Item No. **Report of the Head of Planning, Transportation and Regeneration**

Address 24 BEECHWOOD AVENUE HAYES

Development: Erection of a two storey, 2 bed dwelling with associated parking and amenity space

LBH Ref Nos: **51562/APP/2019/2523**

# PROPOSED SITE PLAN

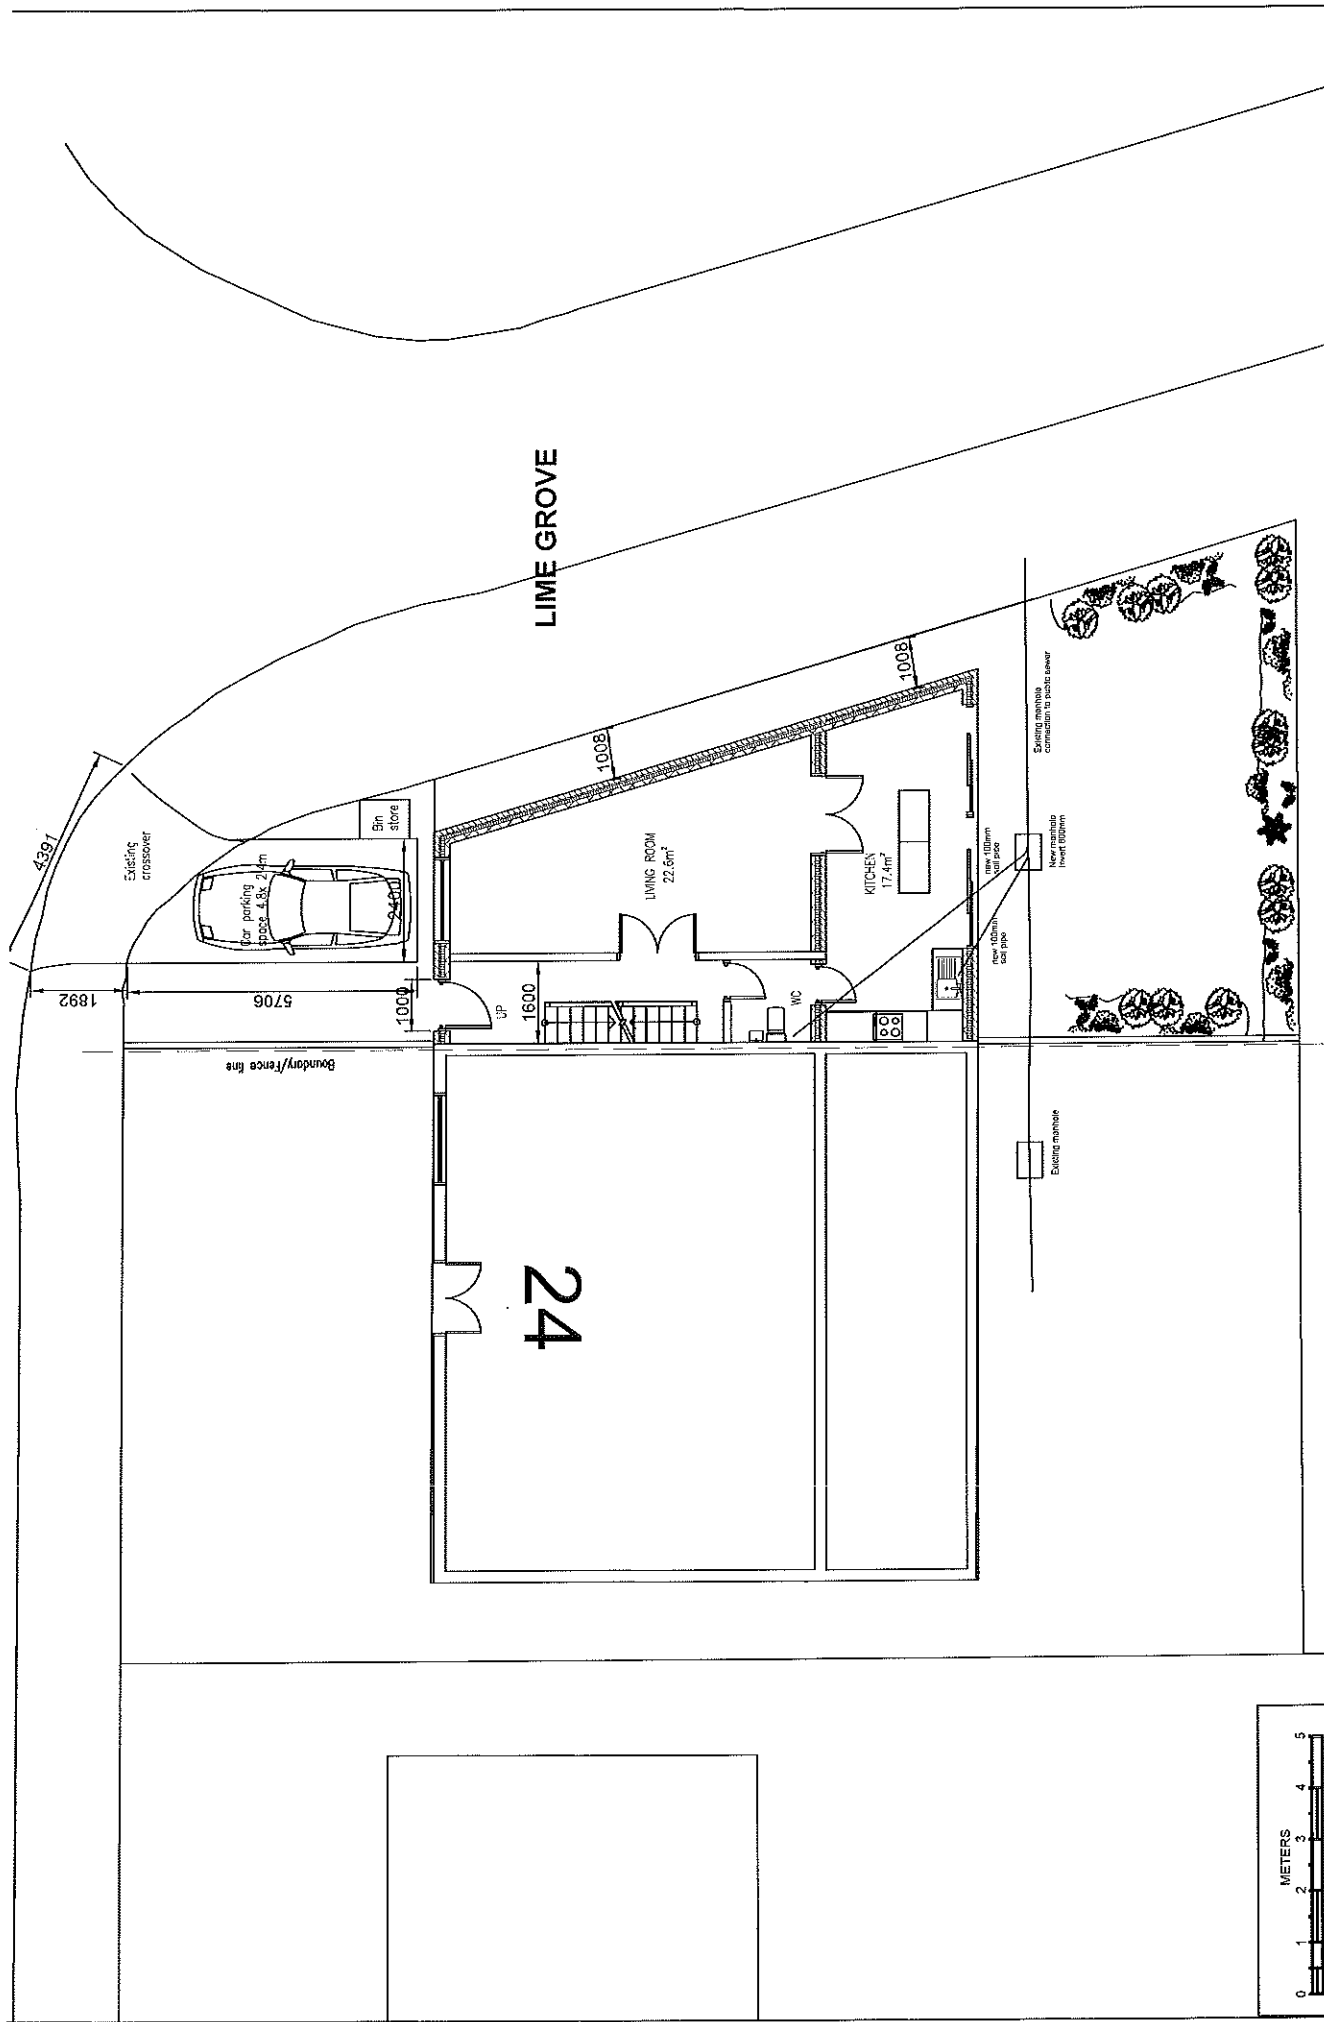
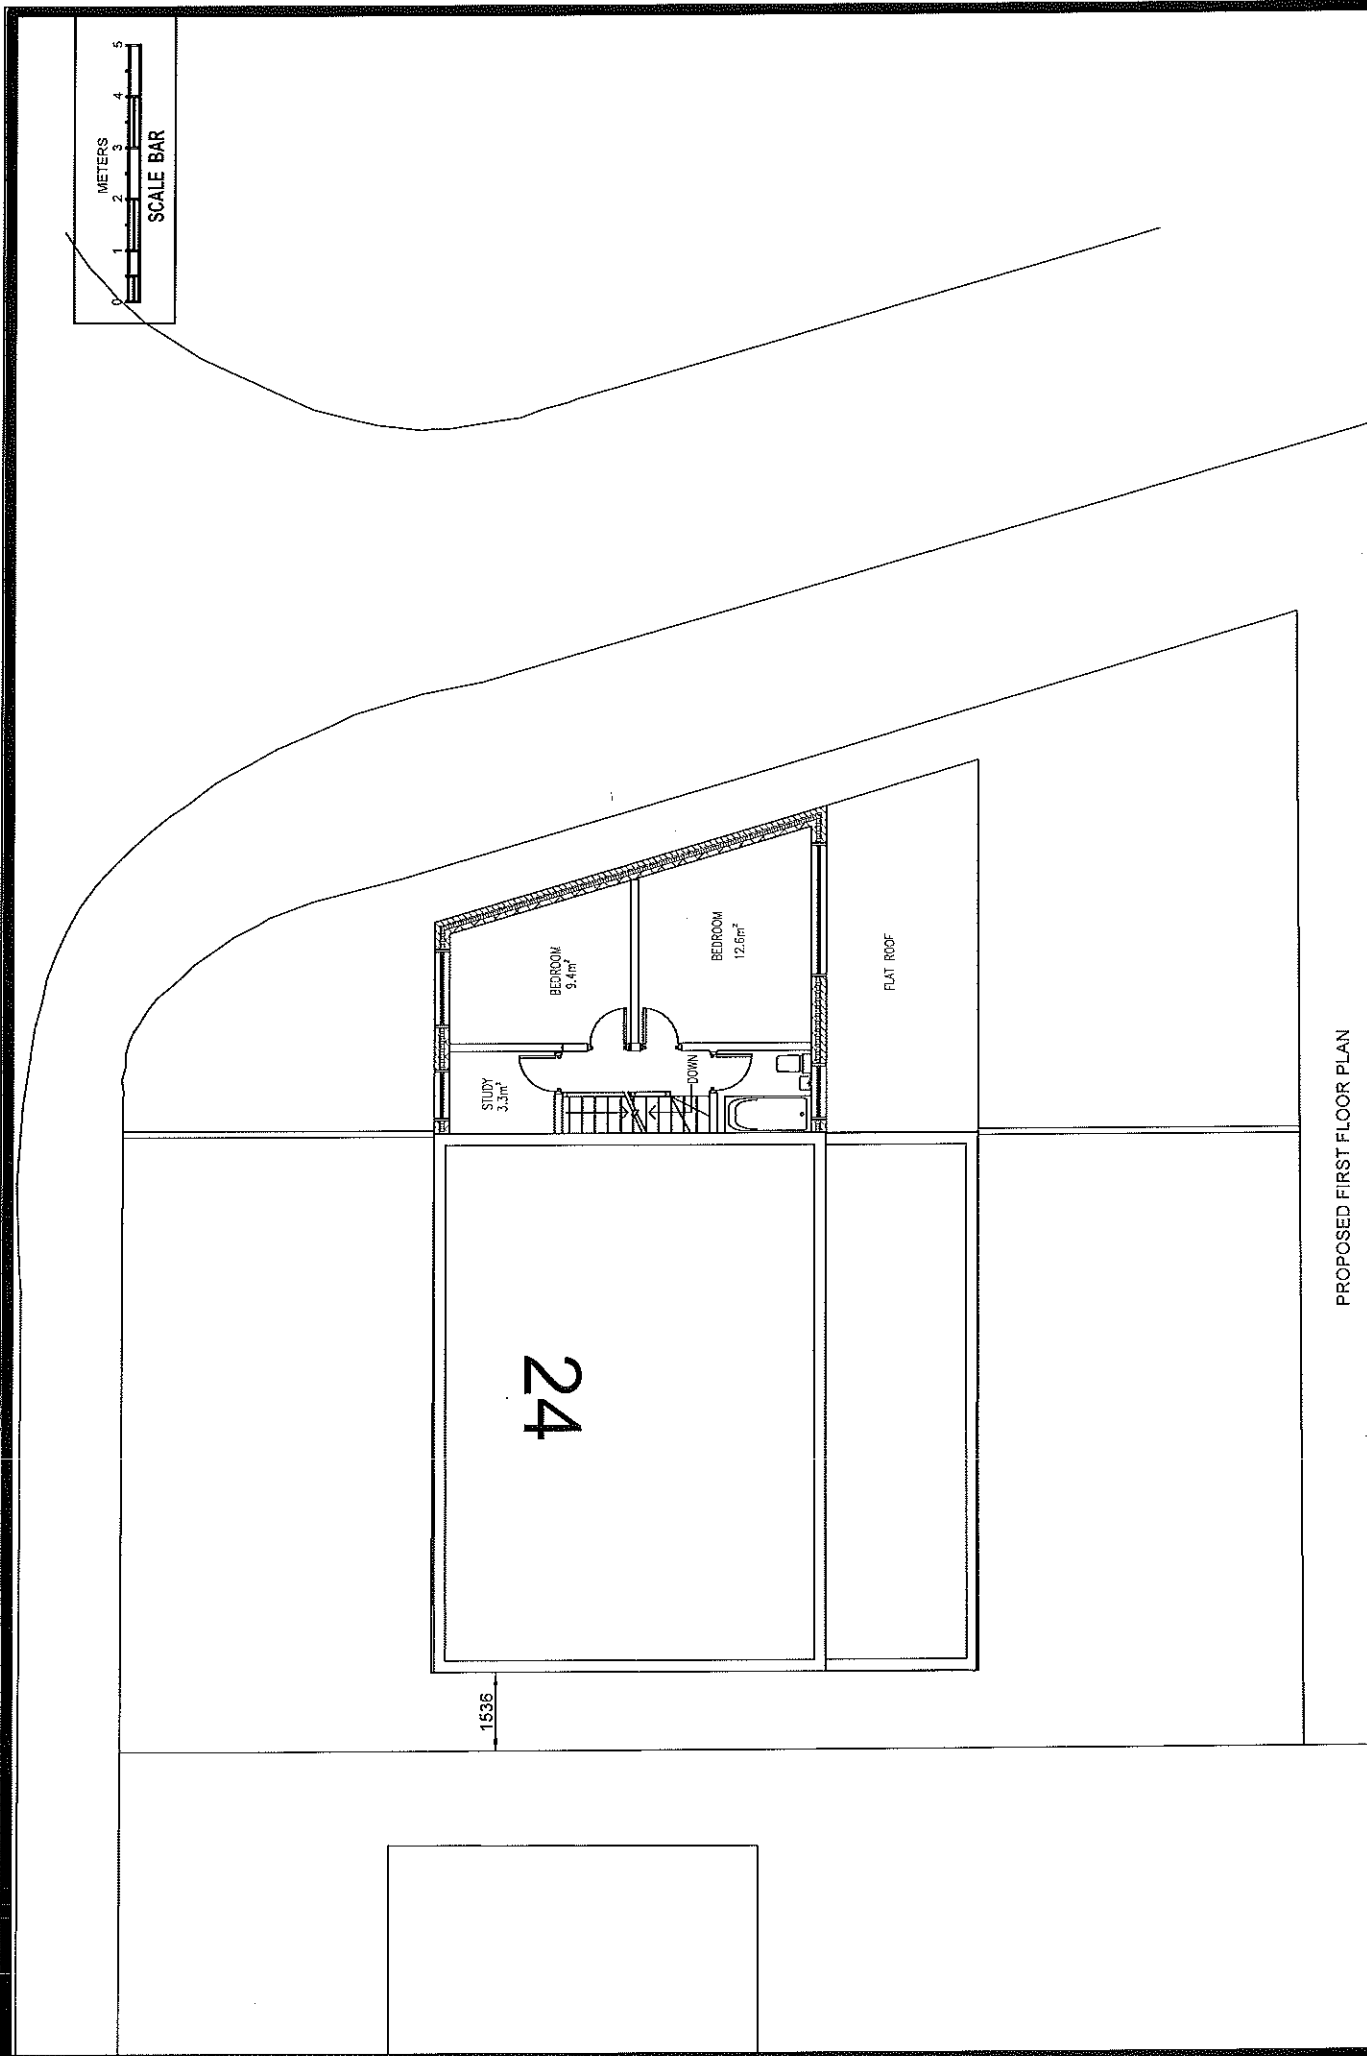
Not only will the proposed dwelling make use of 1 parking space only, it is considered that the upon implementation of the proposals, parking and manoeuvring associated with no. 24 Beechwood Avenue will be restricted compared to that currently associated with the site.

In addition, whilst the submitted drawings depict an existing crossover to be utilised for future occupants upon access and egress. The length of this crossover does not accord with current guidance. It should be noted that the Highway Authority does not look favorably upon access points along junctions where a sufficient linear distance beyond the bellmouth's tangent point is not achieved.

The car parking arrangements on this application reflect those of the previously refused scheme and therefore the Highway Officers previous objection remains pertinent in the determination of this application. The Highways Officer raises severe concern in relation to the proposed layouts and arrangements and recommends refusal.

## PROPOSED FRONT ELEVATION

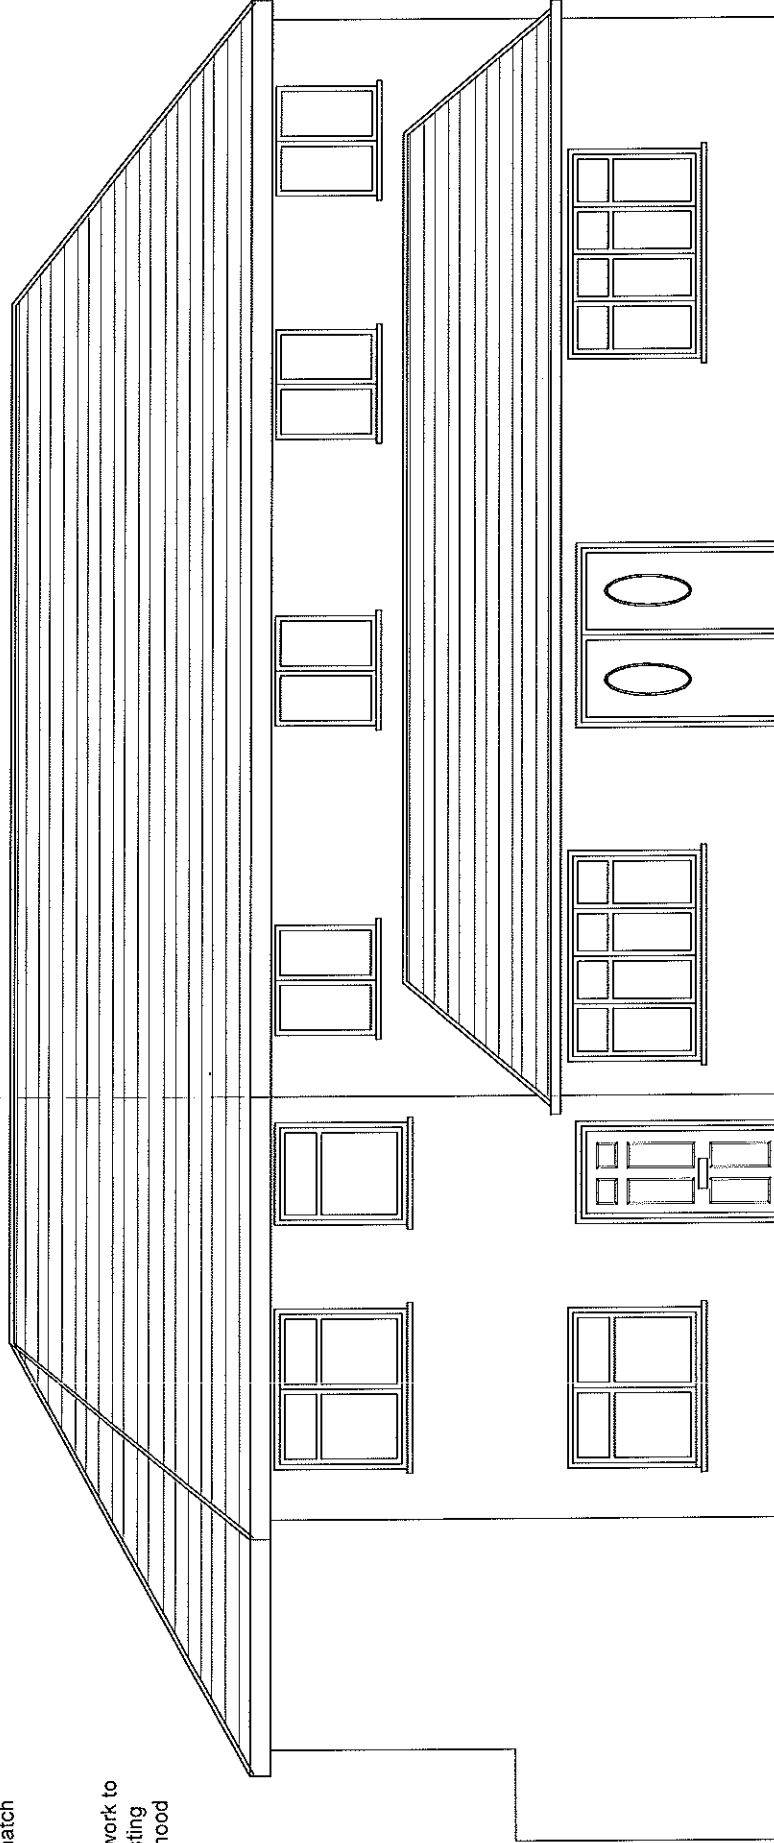
The proposed development, designed as a two storey side extension, would unacceptably break the aforementioned building line. Such development, which would be positioned very close to the boundary with the pavement, would appear dominant and

Notwithstanding the setback from the side boundary, the proposed dwelling would fill in a significantly large portion of the space to the side of the existing dwelling. Due to its siting, width and mass the proposal would significantly erode the space to the side of the dwelling and would be harmful to the spacious and open appearance of the street scene at this point. It is considered that the overall siting, massing and bulk of the proposed development detract from the identity of the street scene.
